Our Ref: BR/41/13/

Demolition of existing buildings and redevelopment of the site with 6 No. two bedroom dwellings

Land to the rear of Holmlea Town Cross Avenue Bognor Regis

Thank you for your internet representation made on 21st May 2013 which has been recorded as '**an objection**' with the comments as follows:

PROPOSED ELEVATIONS ~ PLOTS 4,5 & 6

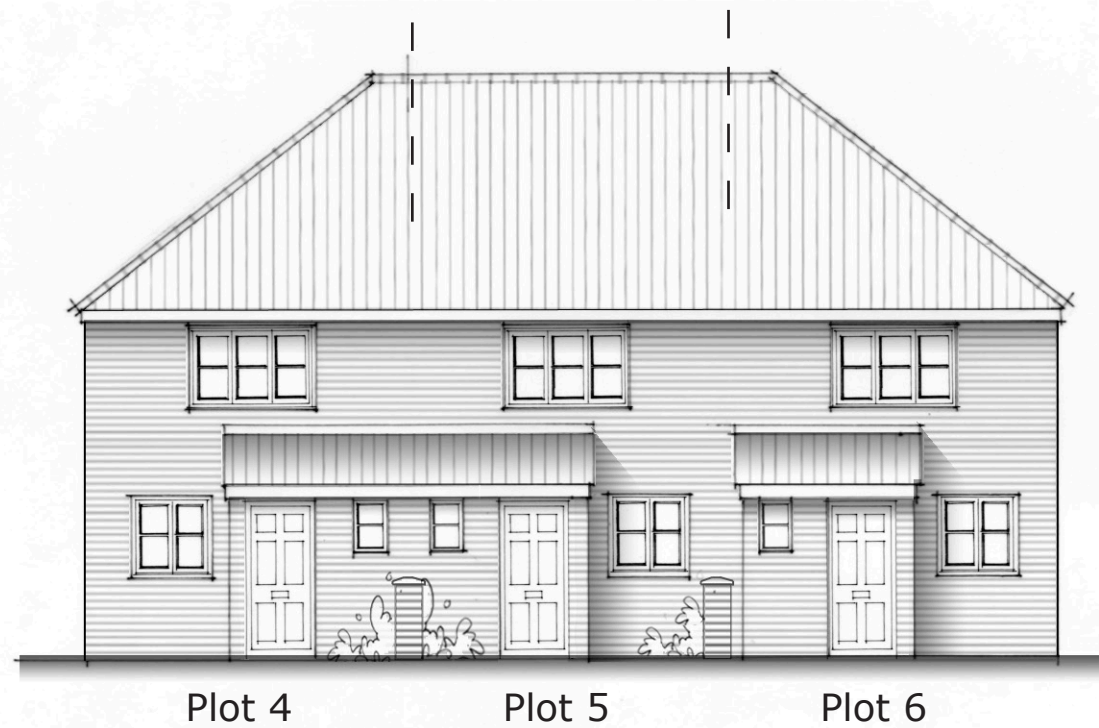
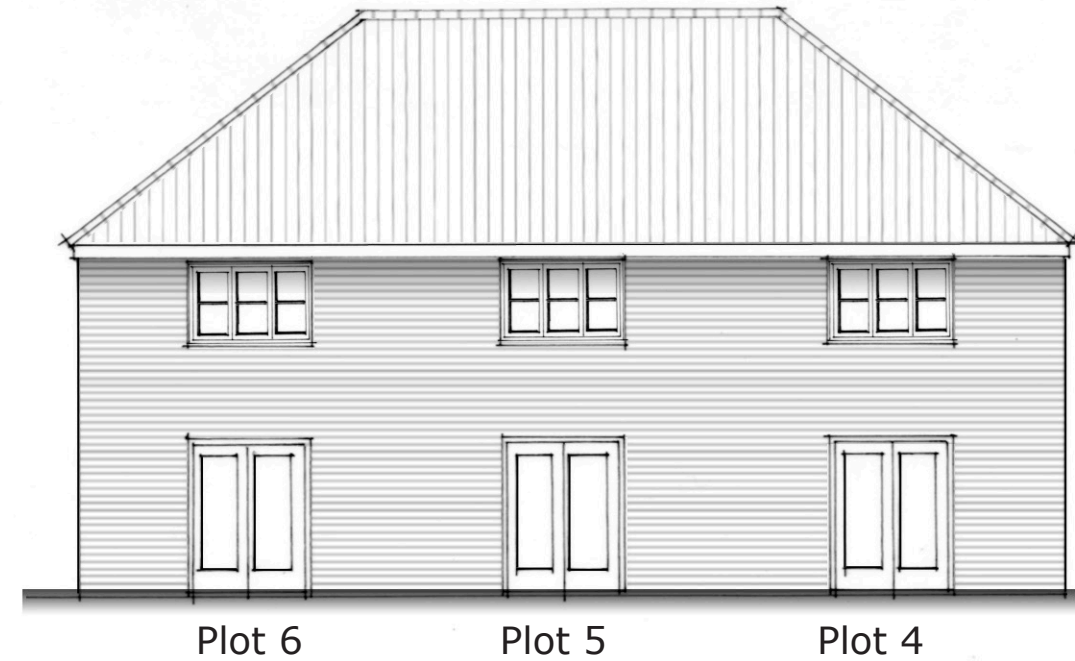
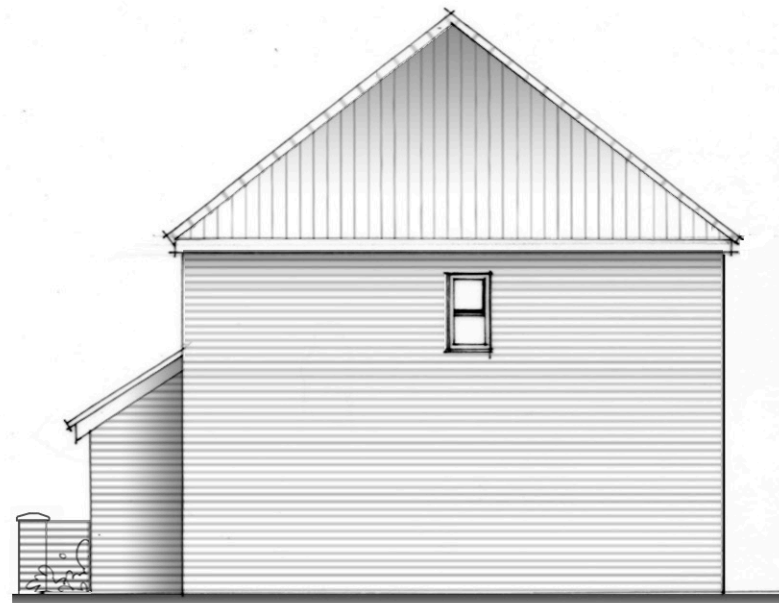
- One of the houses will be fully looking at the rear of my home (5 windows in all) and overlook the rear of my garden (the only private part of my garden now due to other houses being built a few years ago next to my home 4 in all).*
- This house will also overlook my next door neighbour 'Holmlea'.*
- Three of the houses will be fully looking over the rear of my neighbour's gardens in Essex Road (9 windows).*
- The factory currently is only one story high and these houses are to be two story with windows overlooking and removing all our exciting privacy.*
- The rear of my garden will also have reduced daylight.*

- However, they have less windows overlooking themselves, then they do our gardens and homes, nice for them but not for us.

6no two bedroom houses with 9no parking spaces

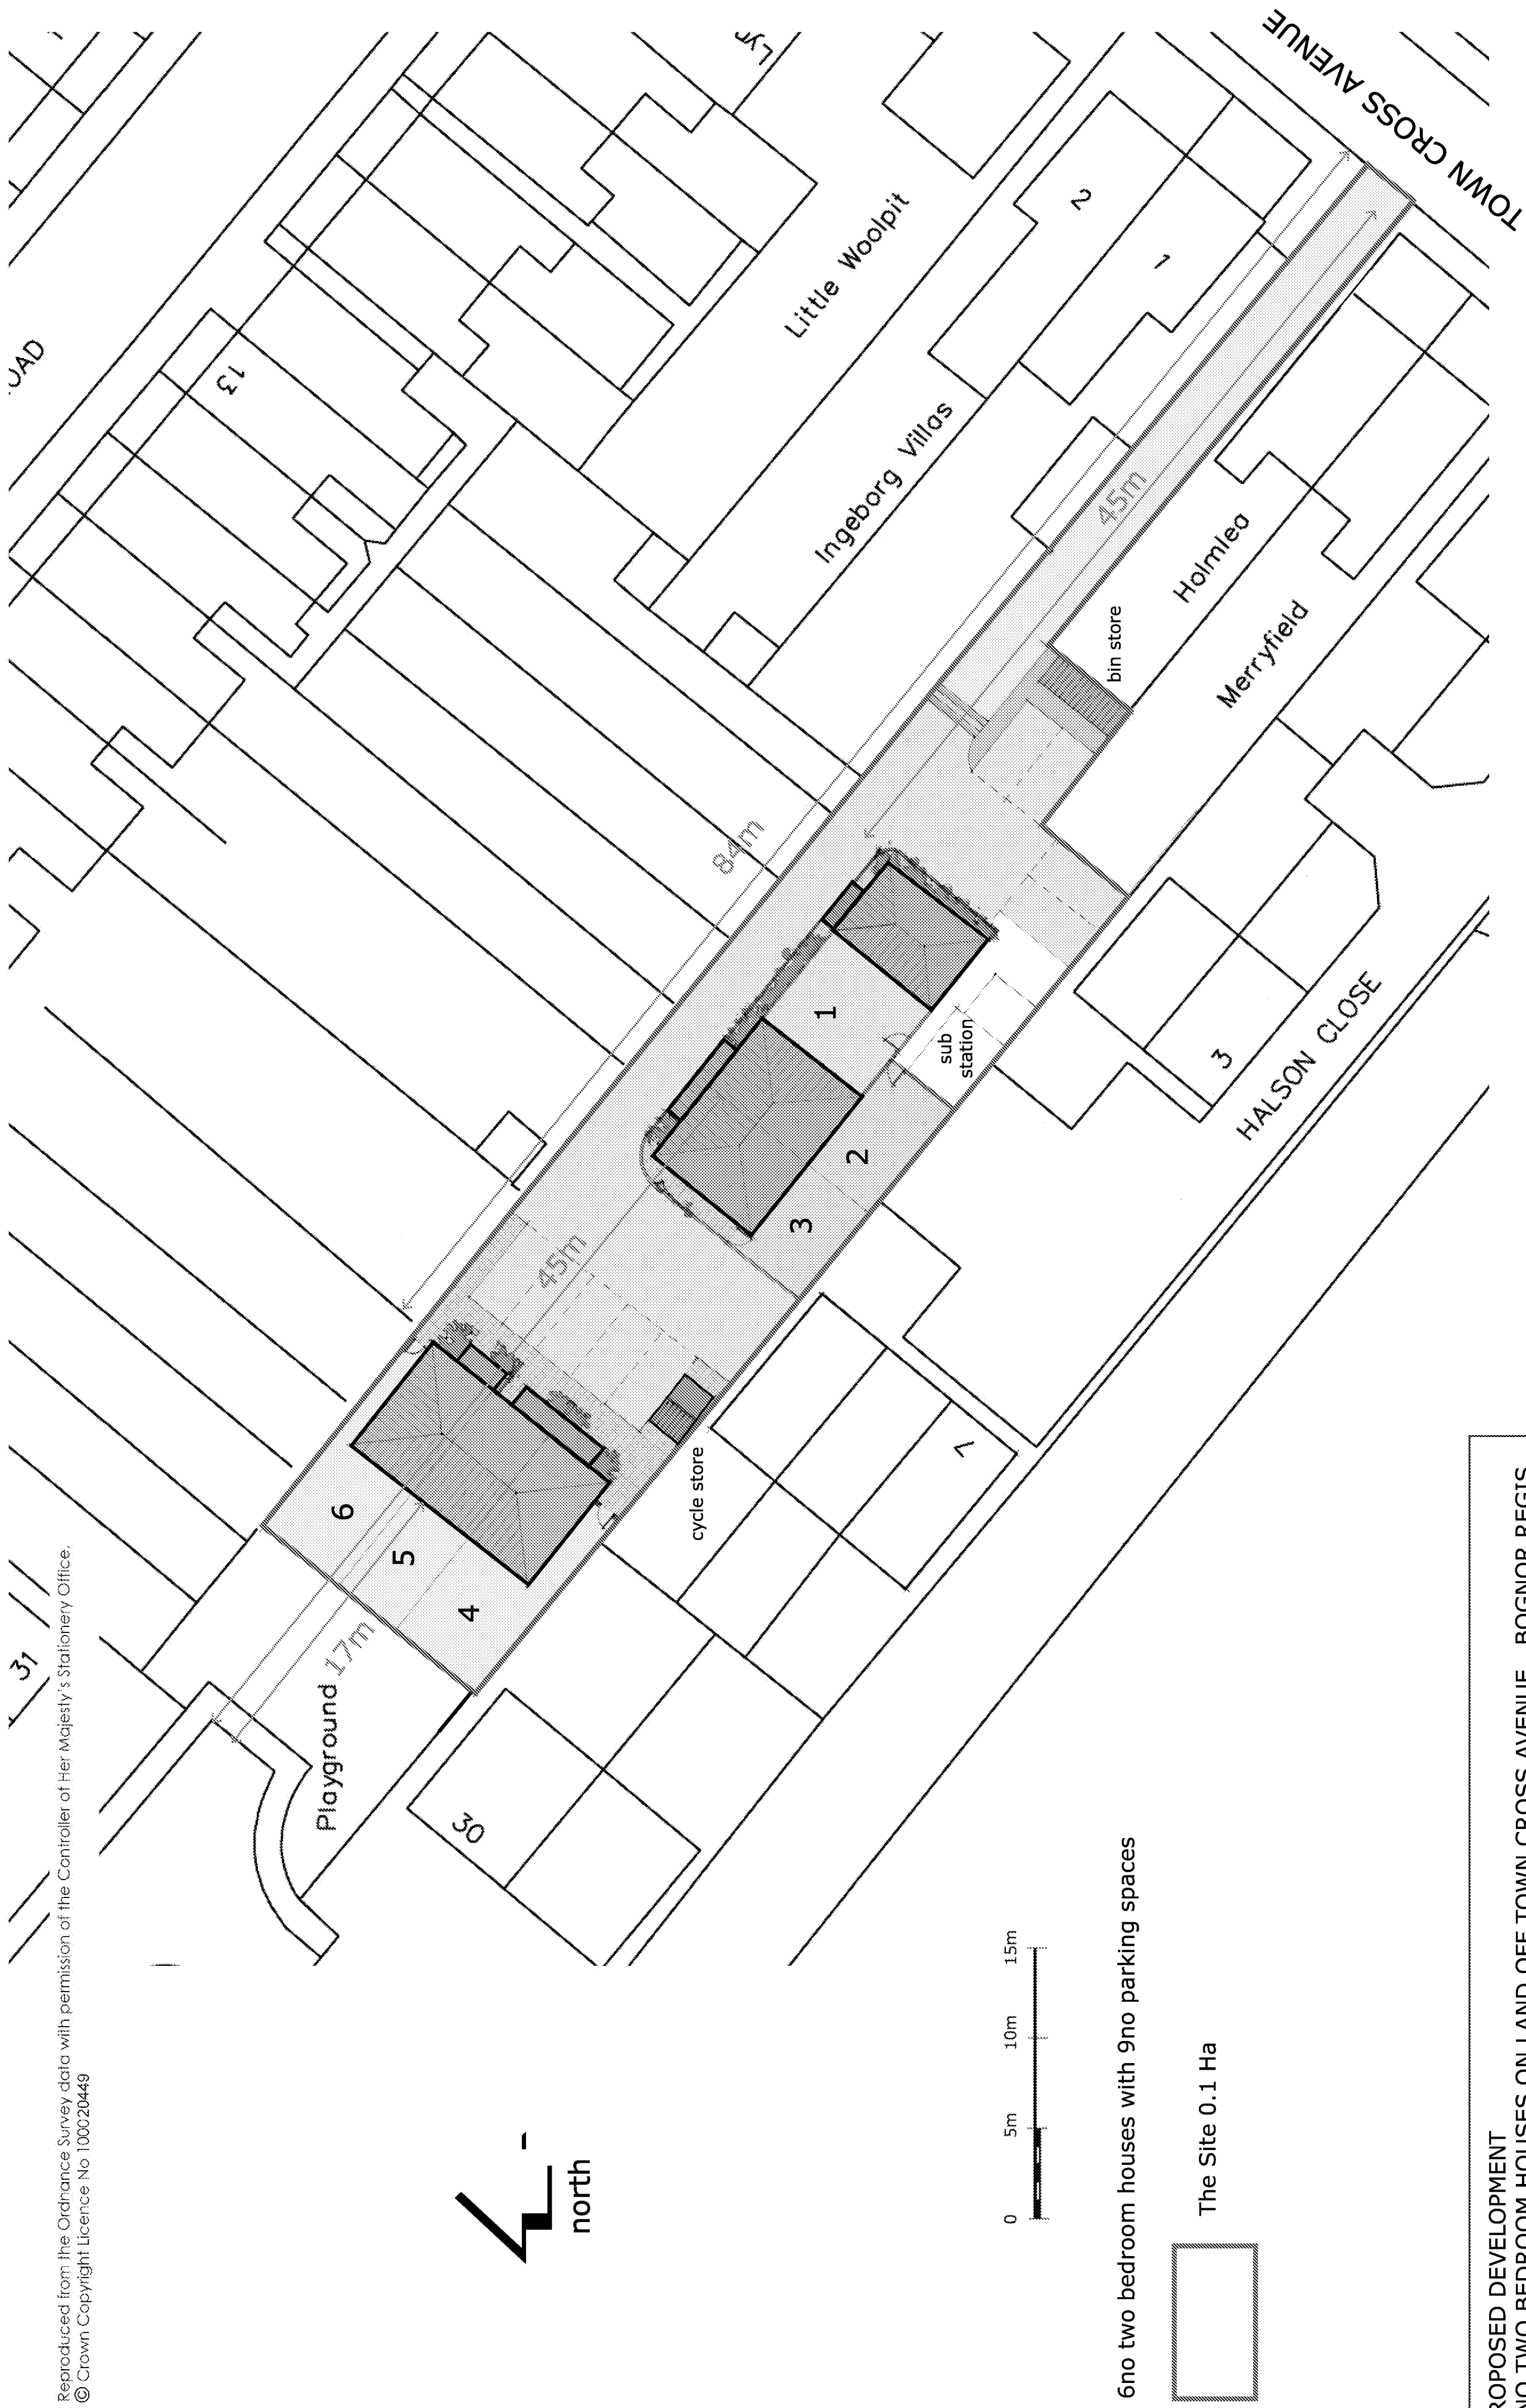
- Please also bear in mind that this will also cause a security issue to our properties as the bins are easily climbed on and then they have easy access to the rear of our gardens.

- The layout of the new houses means that they overlook most of the existing gardens in the area.

- The new road access to them will be at the side of my next door neighbour's home. This will cause her added noise and disruption as with the increase of cars etc. Also, the road itself will be extremely slim less width (barely enough for a van) and I would fear for my home and fences with increased traffic from the new houses if I were her.
